Sundown Solar Development SSD-8911

Thank you for your correspondence of 4 July 2023 and the opportunity to provide comment on the environmental impact statement (EIS) for the Sundown Solar Development (SSD-8911).

NSW DPI Agriculture has reviewed the EIS for the proposed development which comprises 651 hectares (ha) of solar array, a Battery Energy Storage System, and supporting infrastructure, including electricity supply infrastructure, cabling, fencing, operations and maintenance buildings and access tracks (729ha disturbance area within a 2,079ha project site).

Figure 4.1 shows the LSC verification of the disturbance footprint which comprises four LSC classes:

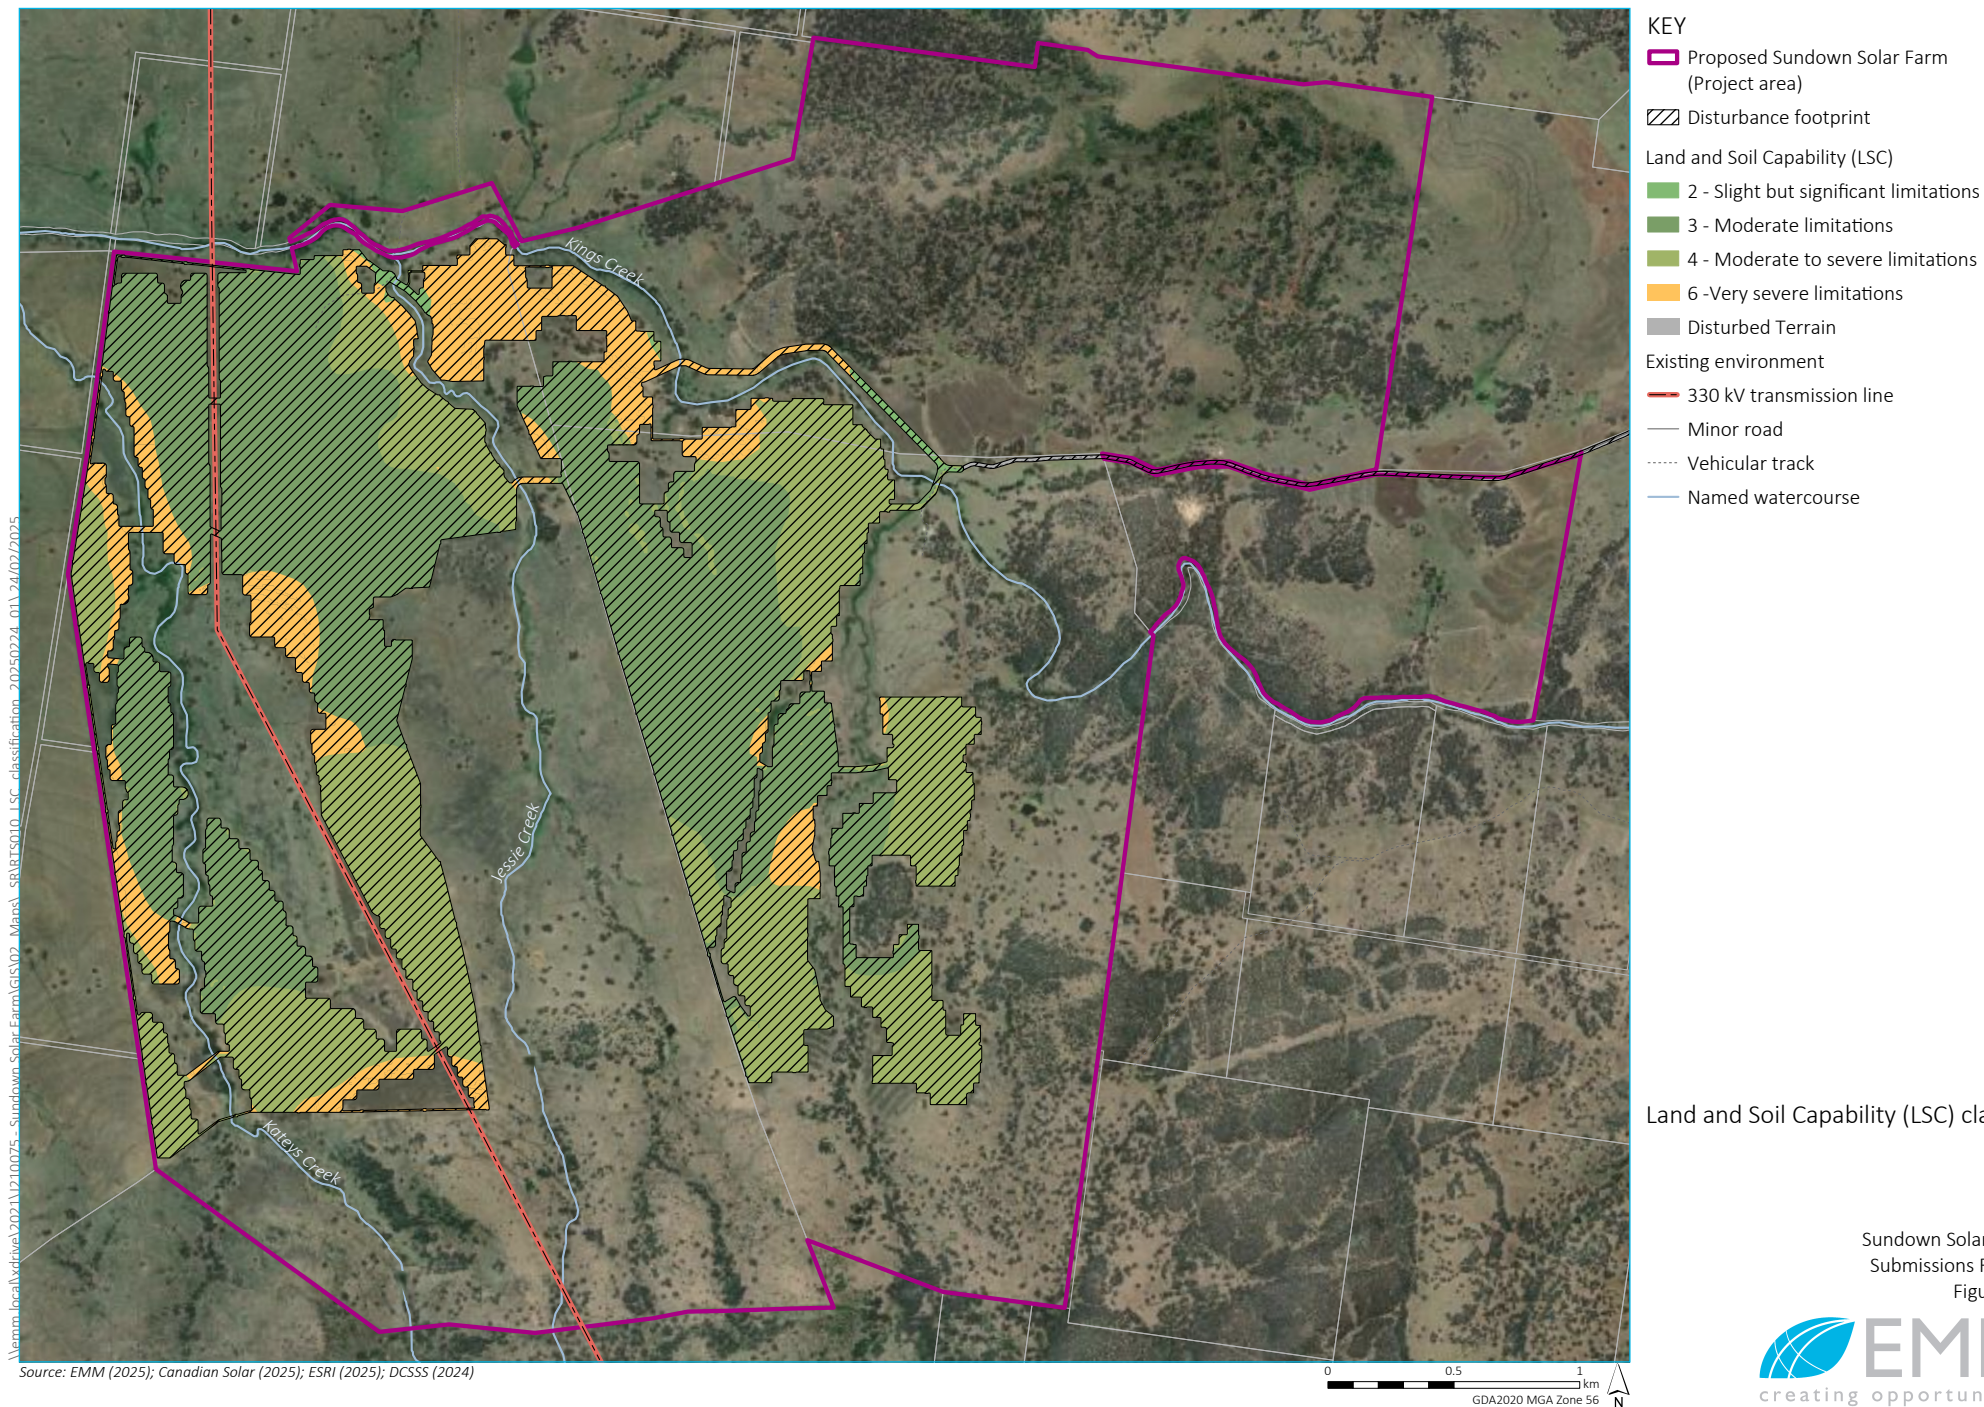
The EIS, based on the soil assessment and site observations has downgraded approximately 363ha of Land and Soil Capability (LSC) Class 3 land to LSC Class 4, leaving around 143.9ha of LSC Class 3 land from a potential 507ha.

The EIS does not verify the extent of Biophysical Strategic Agricultural Land (BSAL) on site, estimated at over 800ha covering LSC Classes 3 and 4 land. It instead assumes that the extent of BSAL is likely to also be revised consistent with the LSC classes. BSAL should not be assumed to be limited to LSC Class 3 only, as there are areas where it does extend to LSC Class 4 lands. The extent of BSAL on the site should only be revised if verified in accordance with the Interim protocol for site verification and mapping of biophysical strategic agricultural land.
